KIRKLEES METROPOLITAN COUNCIL INVESTMENT & REGENERATION SERVICE

Reference No:	2026/44/90822/E
Site Address:	Land Off, Westgate, Cleckheaton, BD19 5DR
Description:	Discharge of details reserved by condition 10 (validation report) on previous permission 2021/93567 for demolition of existing commercial buildings and erection of 180 dwellings with associated works
Recommending Officer:	Farzana Tabasum

DECISION – Discharge of Condition – Split Decision

Condition 10 (Validation Report)

GAS PROTECTION VALIDATION PLAN

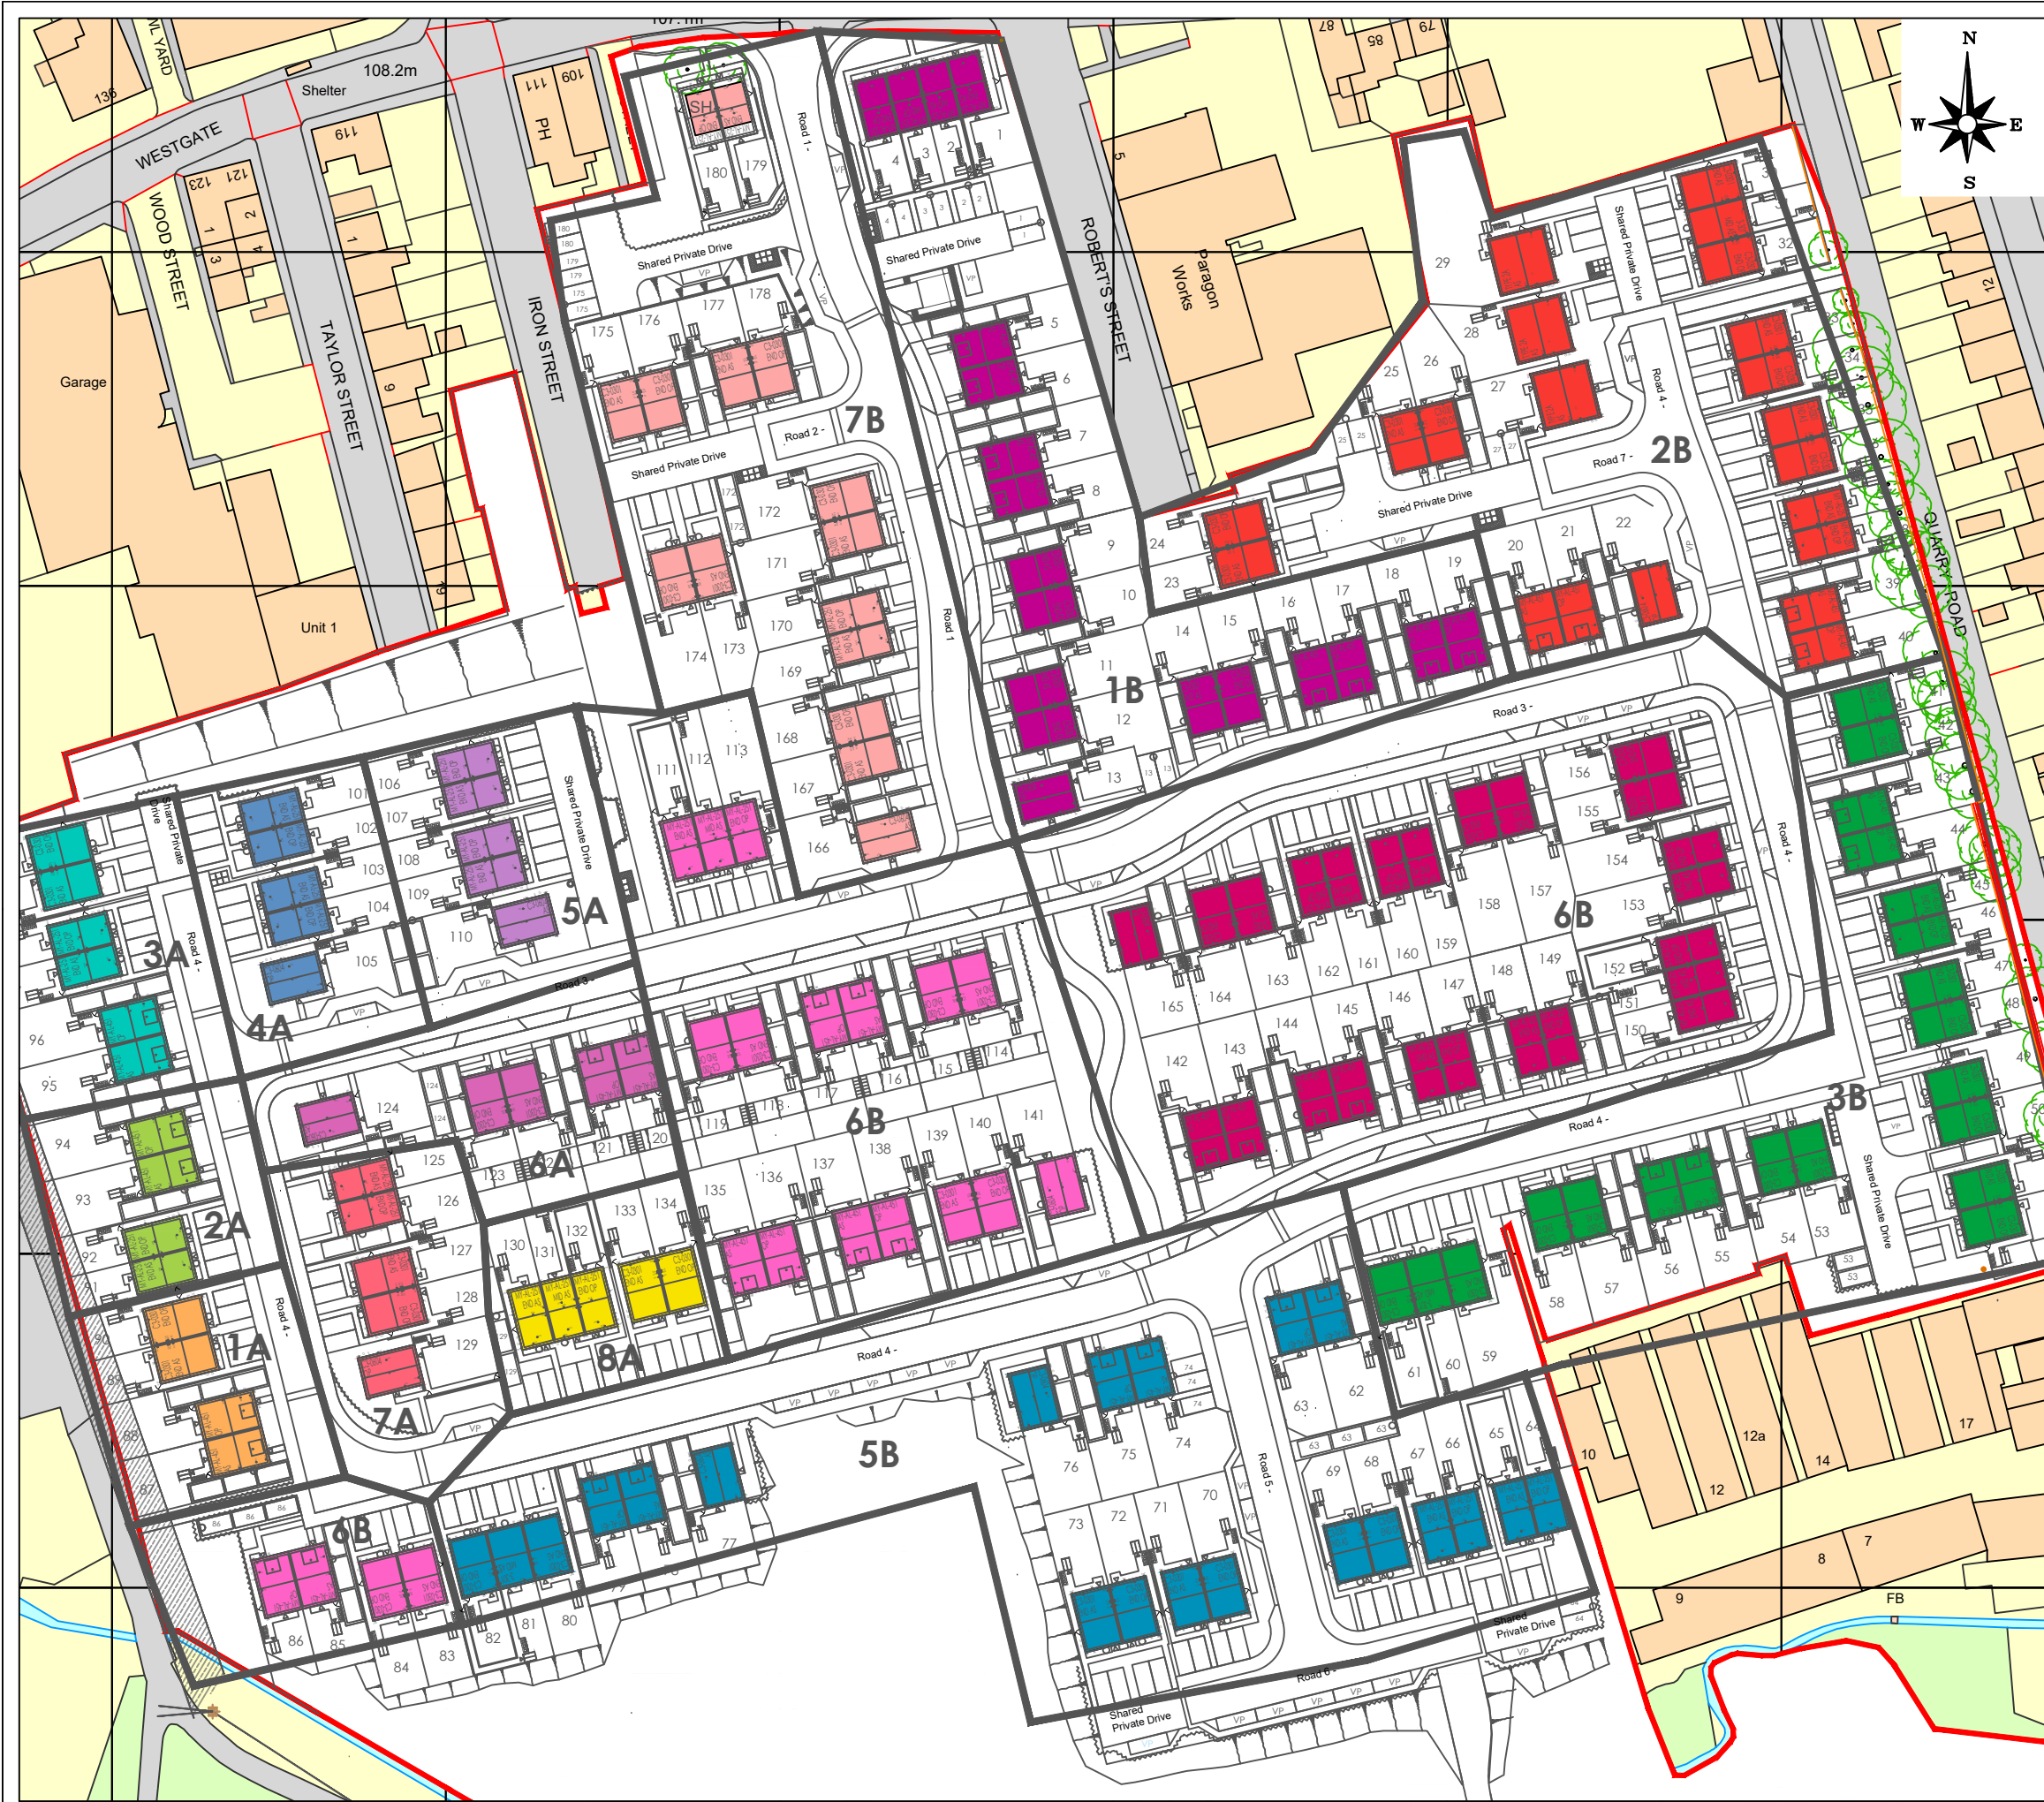
Environmental Health has been consulted. Its initial comments dated 31 July 2026 (via email) they identified discrepancies in drawing 3043/21 concerning the plot shading, gas protection classifications, inspection frequencies and

block labels. The above is the revised report submitted to address these matters.

The revised report 3043/9A supersedes the February 2026 report and includes the updated Gas Protection Verification Plan, drawing 3043/21. It sets out the gas protection measures to be installed, together with the arrangements for their inspection, testing and verification.

The Gas Protection Strategy & Verification Plan (February 2026, 3043/9) with revised Drawing 3043/21 (Gas Protection Validation Plan) are accepted. However, verification of the gas and hydrocarbon protection measures will be required following installation in accordance with the approved verification strategy, with the verification documentation submitted as part of the overall remediation verification process
